**Subject: 421 Warren Avenue  
Preliminary Level III Site Plan Application  
Response to Peer Review Comments**

We have received and reviewed Woodard & Curran's peer review comments dated March 3, 2014 and Tom Errico's comments dated March 12, 2014 regarding the Preliminary Level III Site Plan Application for the 421 Warren Avenue Commercial Complex project. We offer our responses to these comments. For ease of reference we have repeated each comment in *italics* followed by our response.

**WOODARD & CURRAN COMMENTS DATED MARCH 3, 2014**

GRAVEL WETLAND #2 PLAN VIEW
SCALE: 1" = 20'

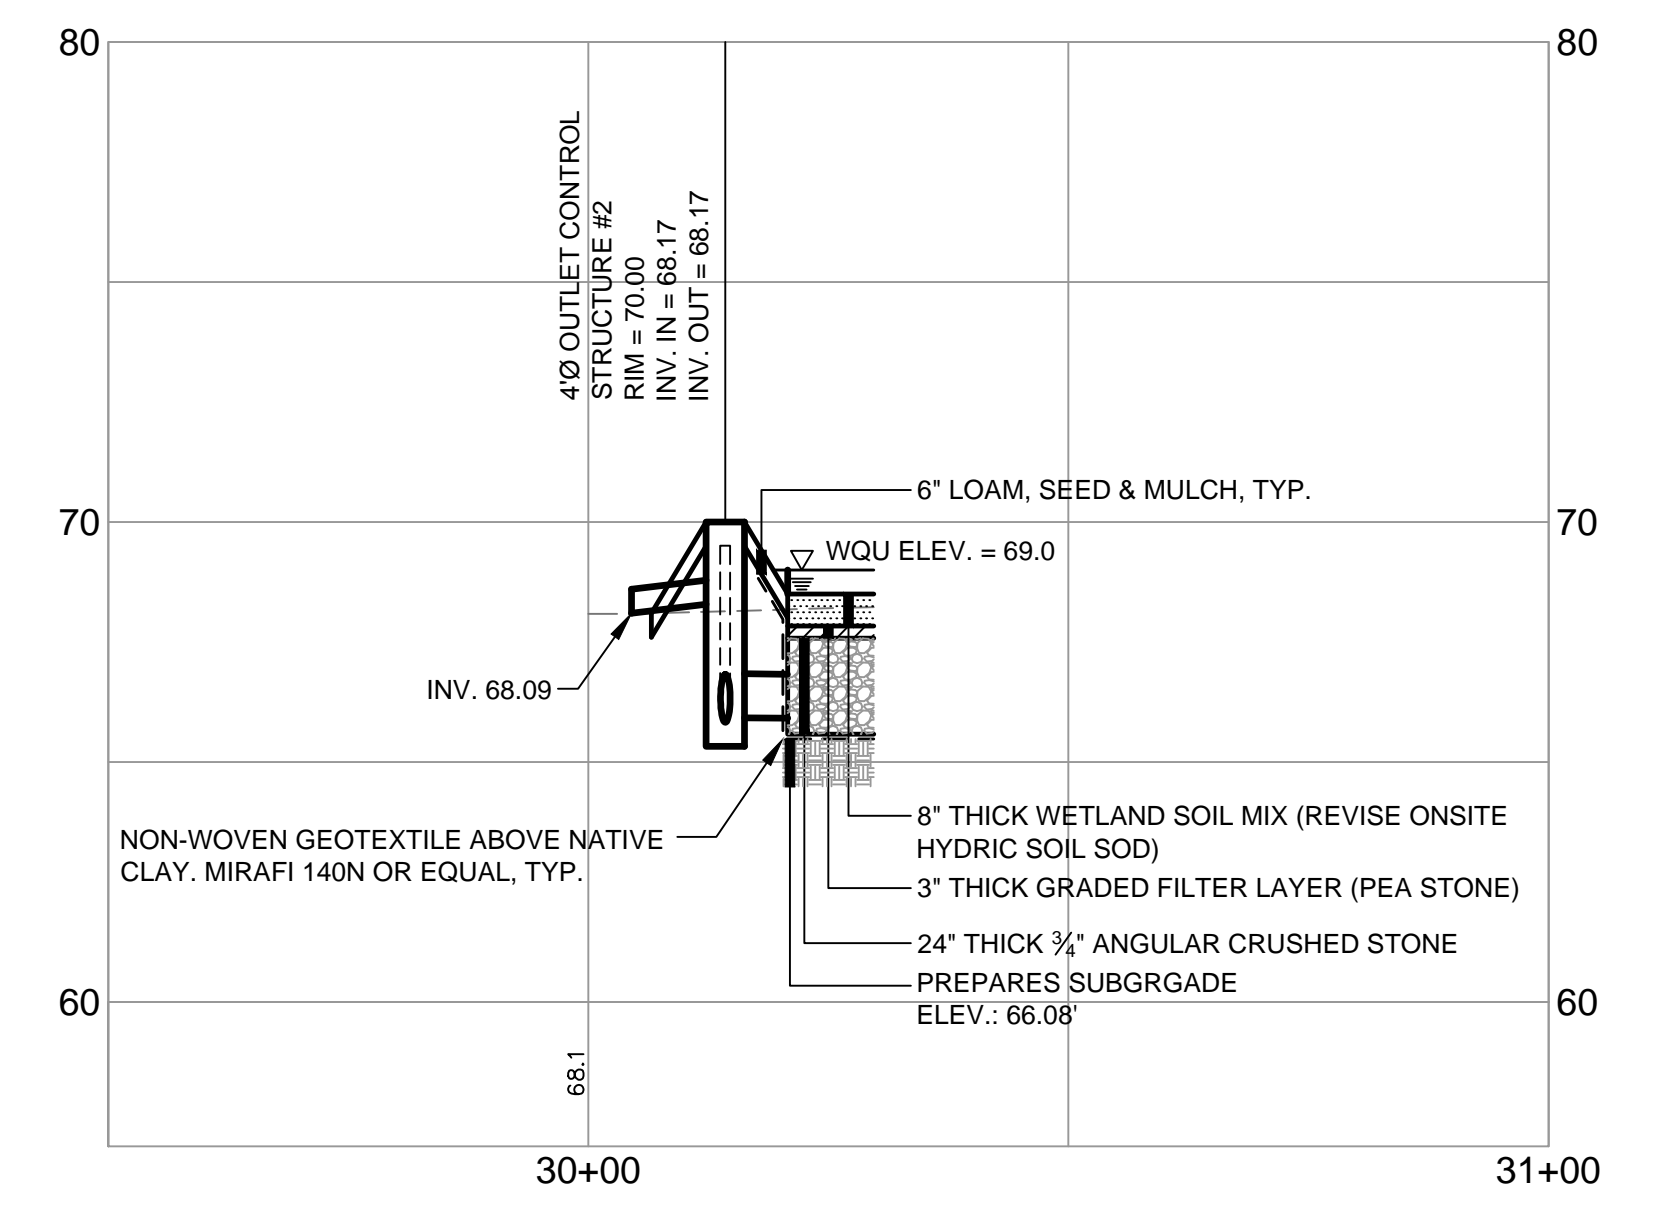
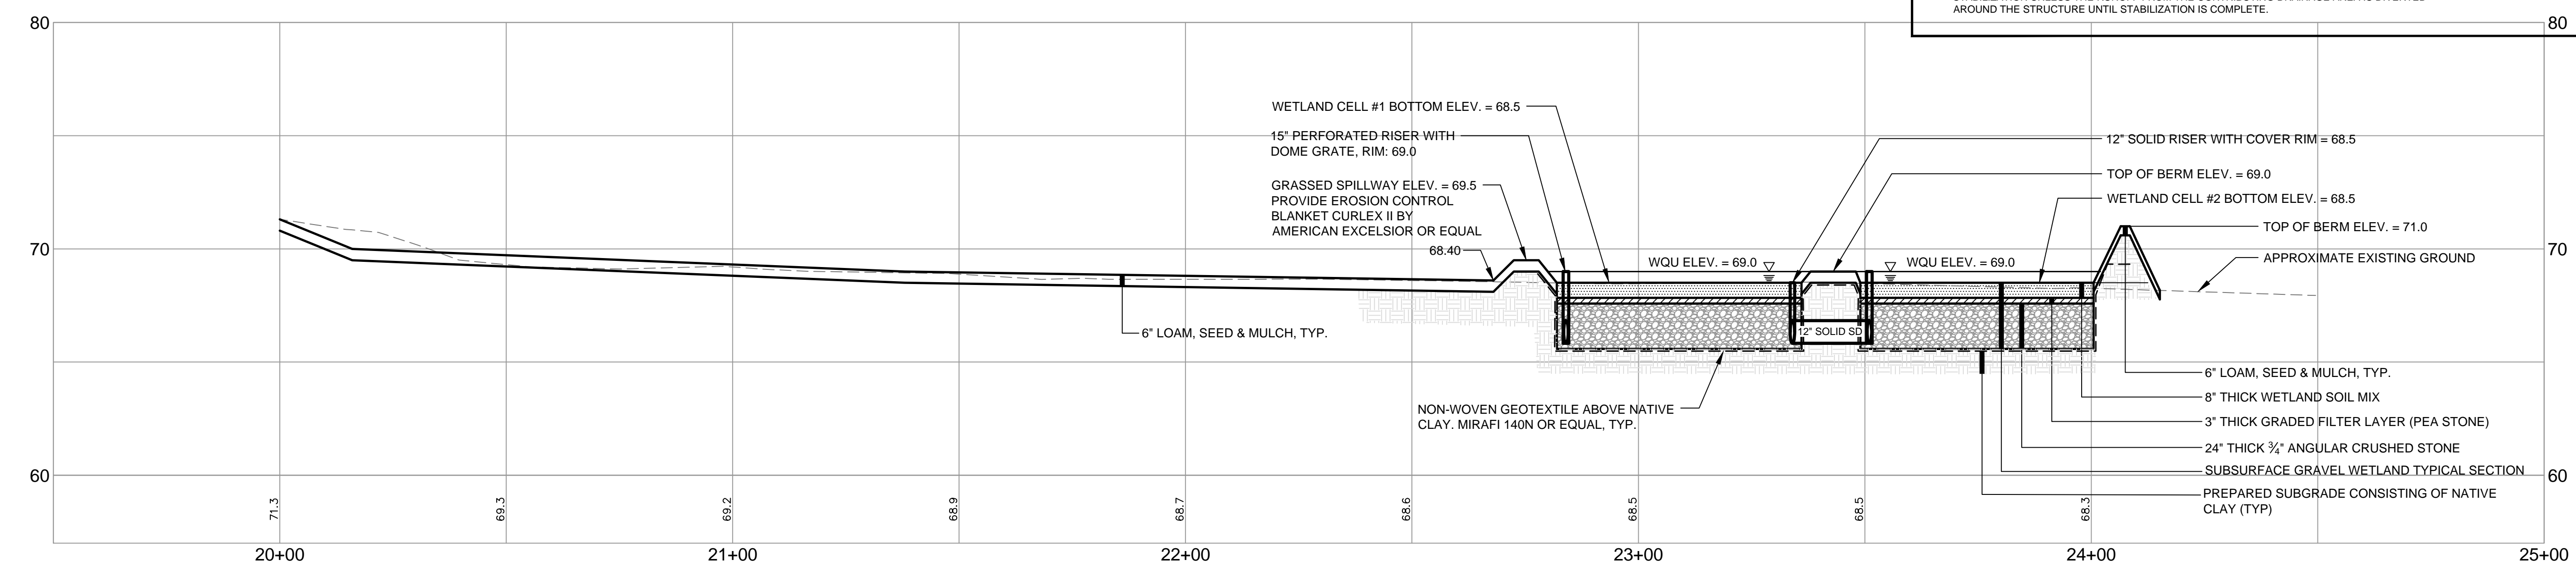
*a) On Sheet C-4.2, the titles for the plan view and section view incorrectly note Gravel Wetland #1; these should state Gravel Wetland #2.*

Sheet C-4.2 has been corrected to state Gravel Wetland # 2.

DRAWN: DED DATE: NOVEMBER 2013
DESIGNED: SRB SCALE: 1"=30'
CHECKED: SRB JOB NO. 195350330
FILE NAME: SP-M104-SITE
SHEET **C-3.0**

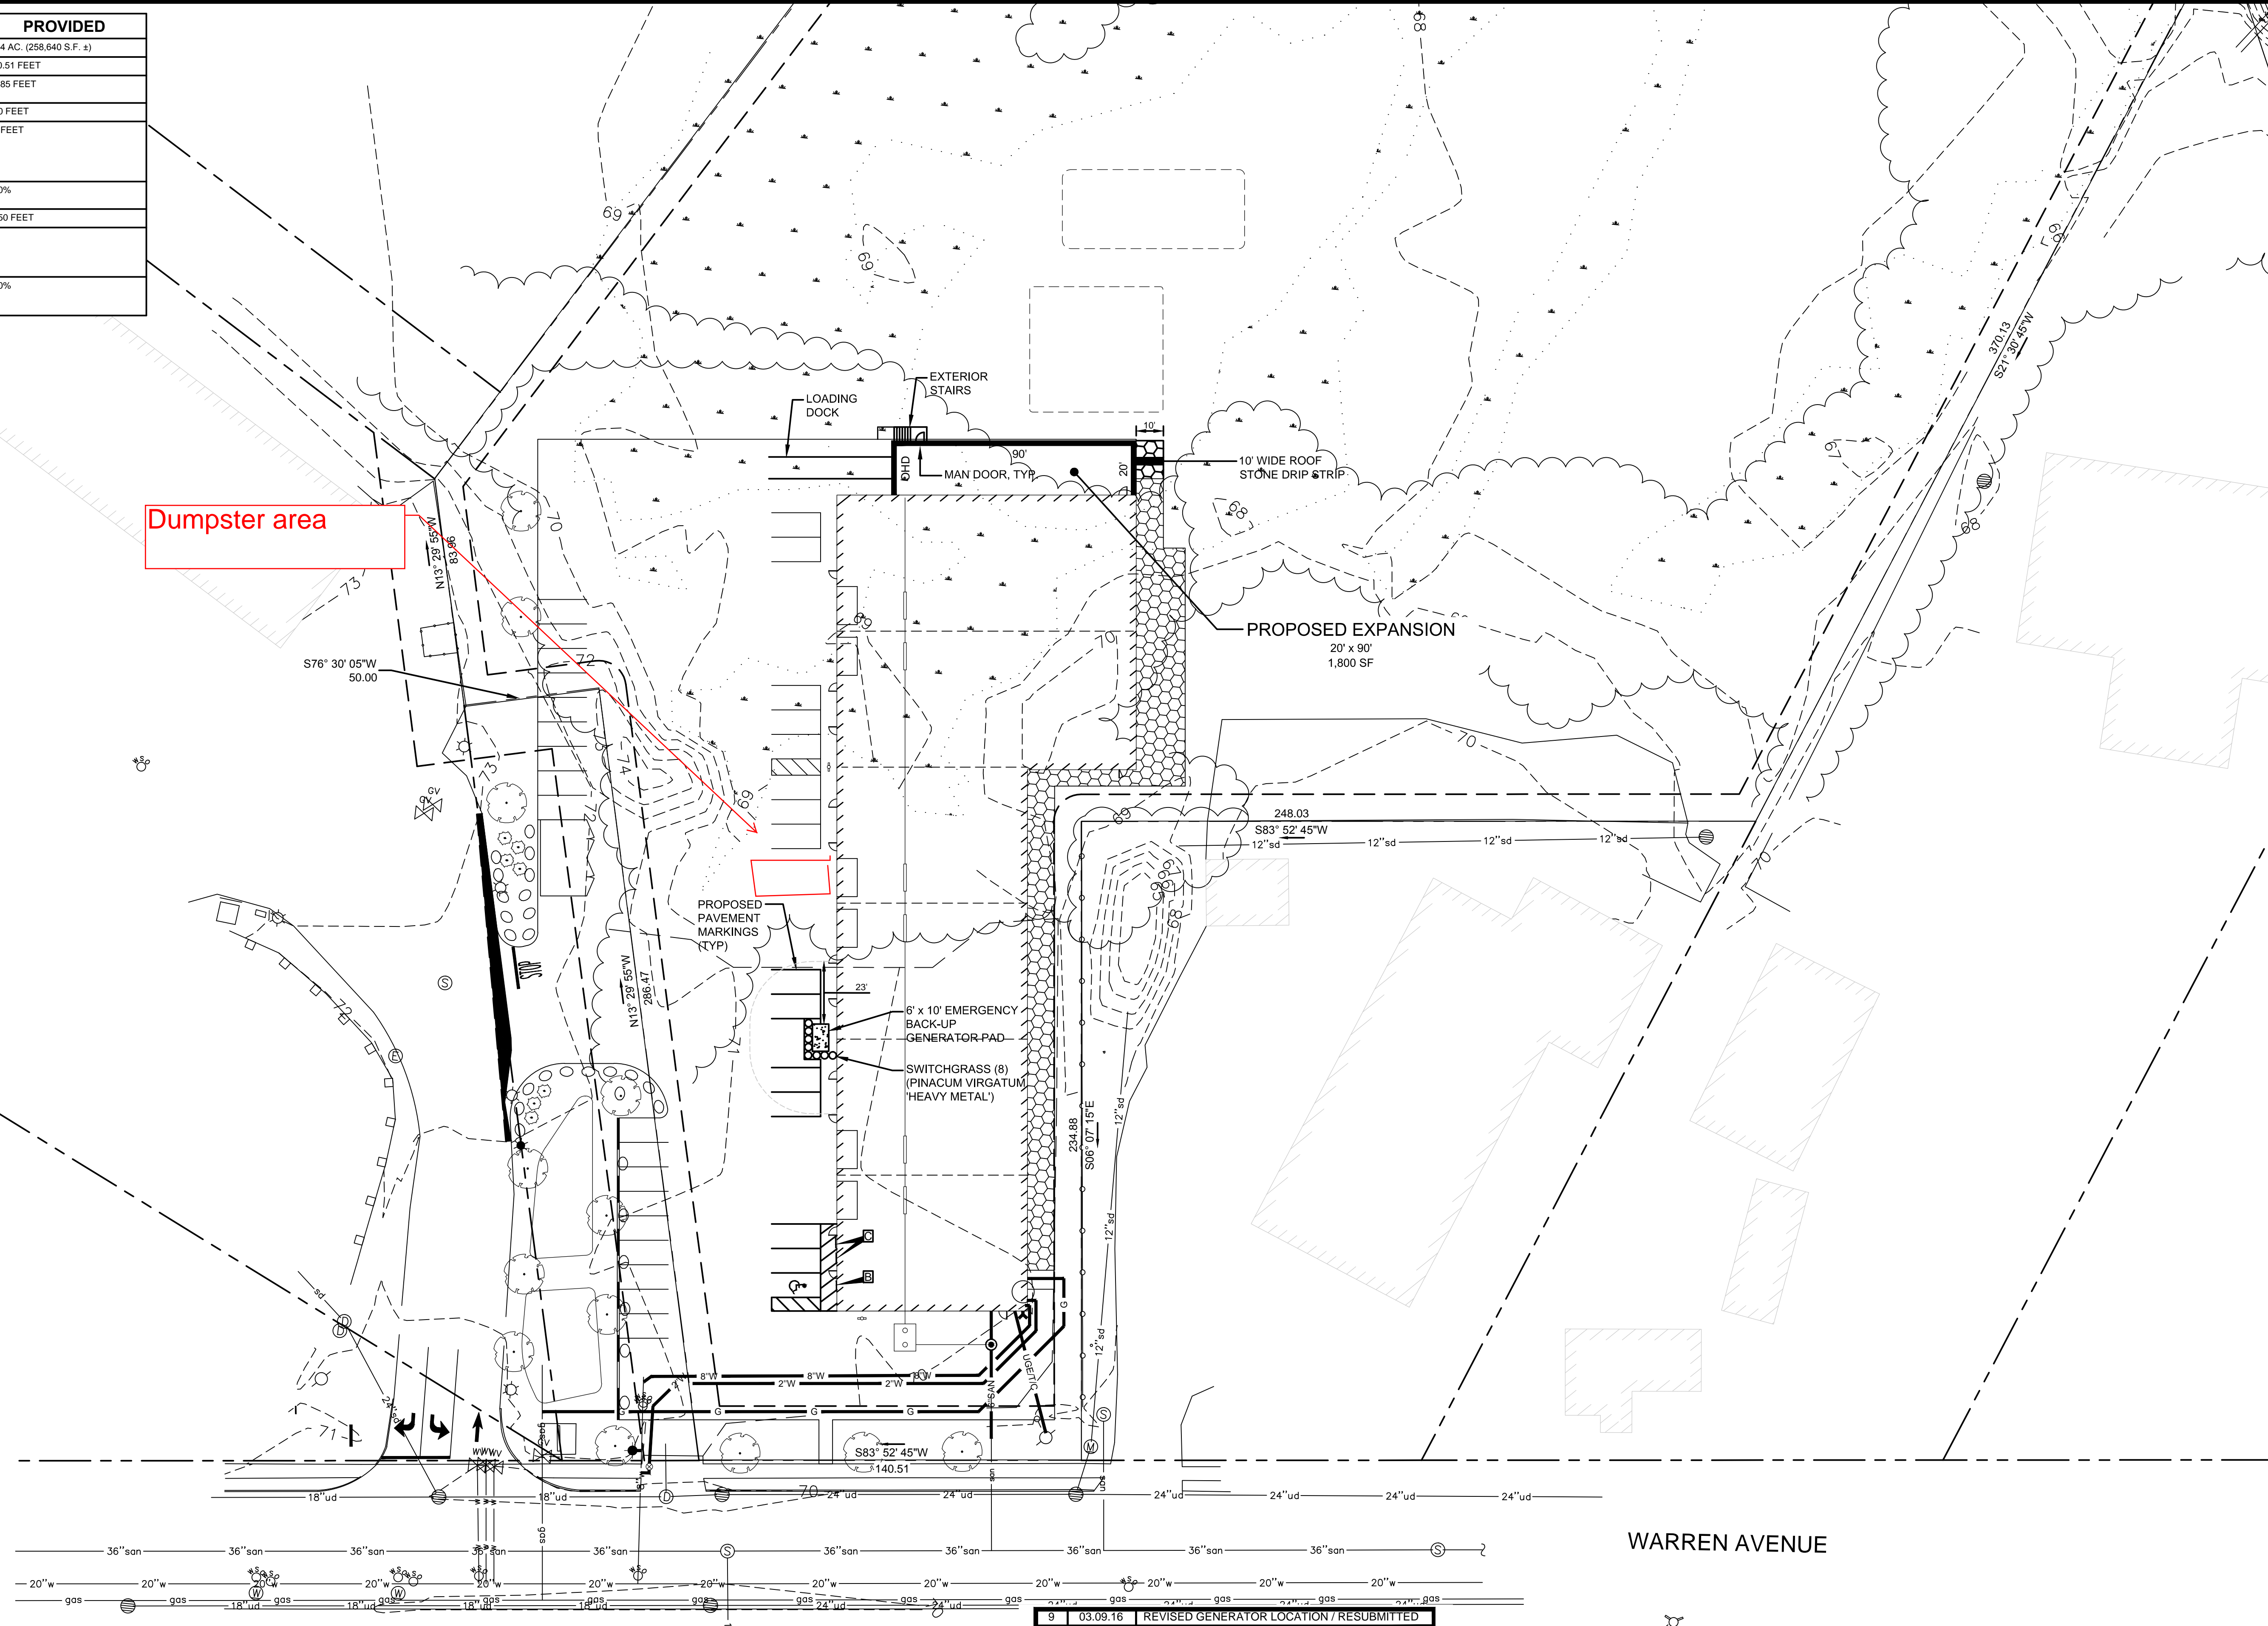
- a) *The Applicant has noted that the project requires a MaineDEP NRPA Tier III permit for approximately 25,093 SF of wetland impacts, which is being submitted concurrently with the City Site Plan Application. Evidence of receipt of this permit shall be required prior to the start of construction.*

The site has been re-designed to impact 14,323 SF of wetlands which will require a MaineDEP NRPA TIER I permit. The NRPA Tier I has been filed with the MaineDEP and its review will run concurrent with the Site Plan Review. See updated site plan sheet C-3.0 for proposed wetland impacts.
